CITY OF ALBUQUERQUE

January 3, 2019

RE: Las Lomas Plaza – Unit 2 Bldg 1
2105 Vista Oeste NW
Permanent C.O. – Not Accepted
Temporary C.O. - Accepted
Engineer's Certification Dated 12/17/18
Engineer's Stamp Date: 03/28/18
Hydrology File: H10D031

LAS LOMITAS PLAZA - PHASE II GRADING & DRAINAGE PLAN

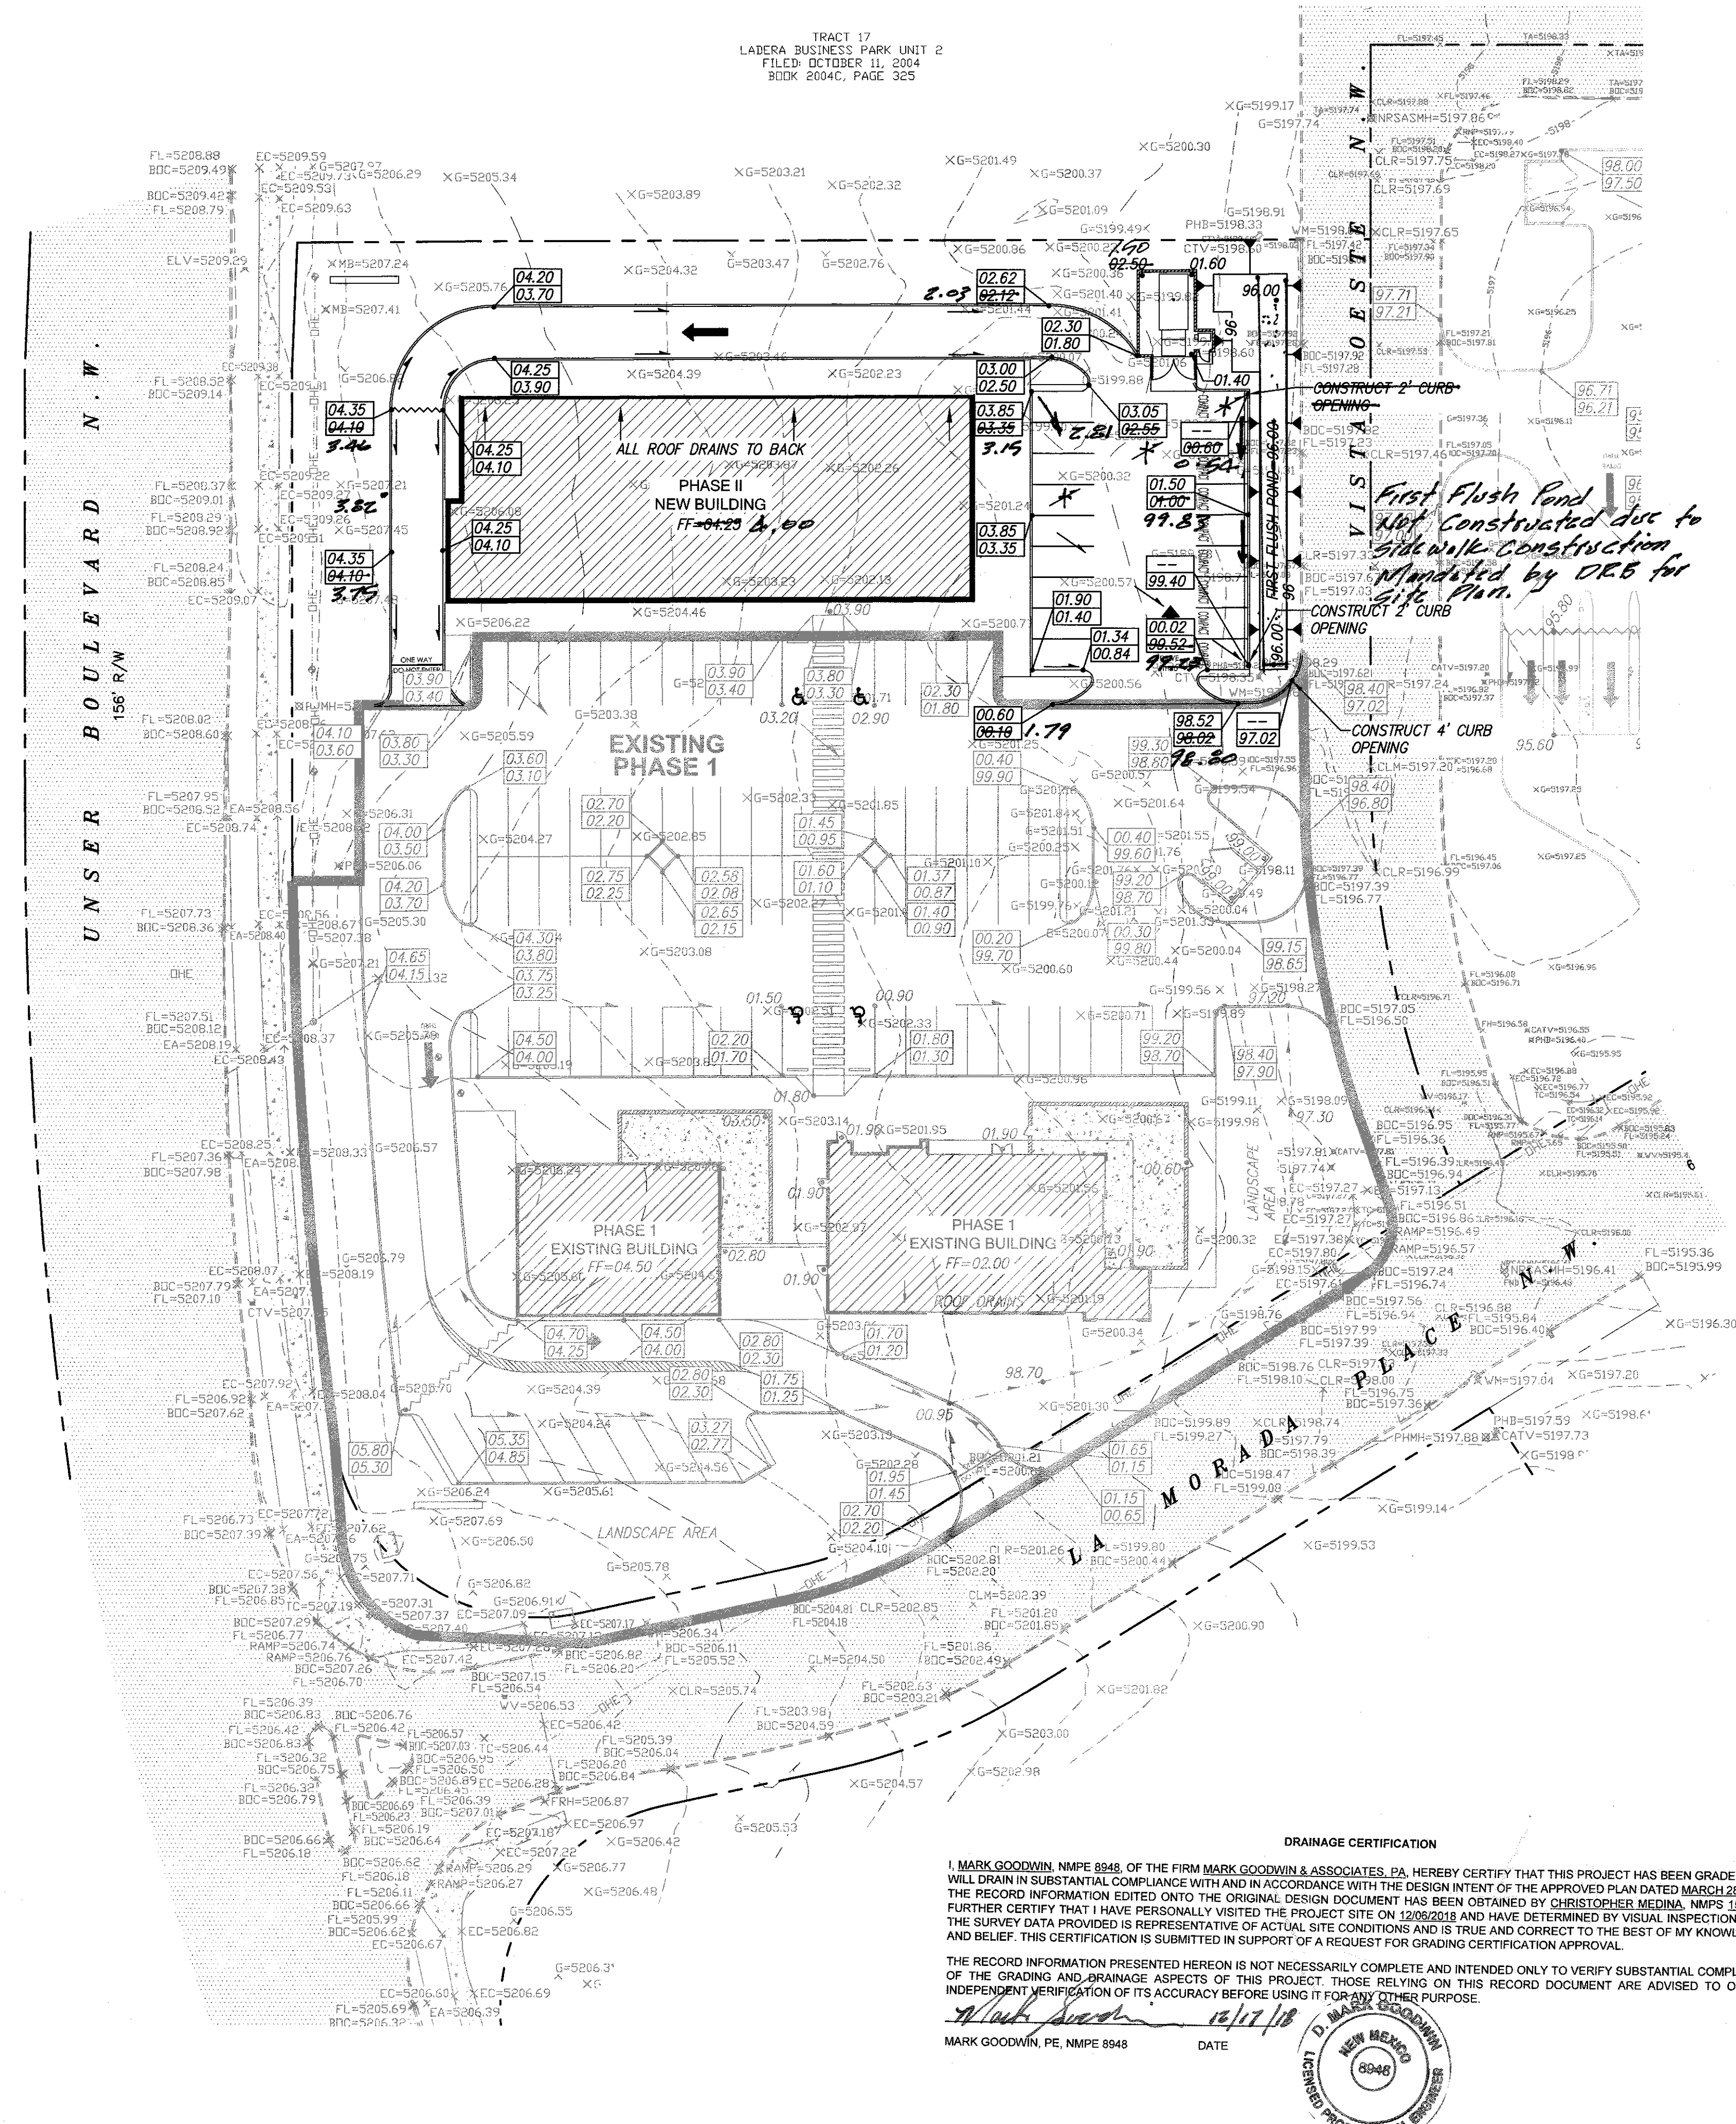
Prior to Hydrology's approval of Permanent Release of Occupancy, since the Owner is electing to do Payment in Lieu for the required stormwater quality volume of 770 cubic feet since the stormwater quality pond was not installed. The Payment in Lieu payment (Amount = 770 CF x \$8/CF = \$6,160.00) for the required stormwater quality volume must be made using the attached City of Albuquerque Treasury Deposit form. The Owner needs to bring three copies to the cashier on the Building Permits side of the ground floor and pay the fee. Once this is done, please resubmit for Permanent Release of Occupancy and please provide Hydrology with one of the copies showing the receipt. This resubmittal will be at no cost.
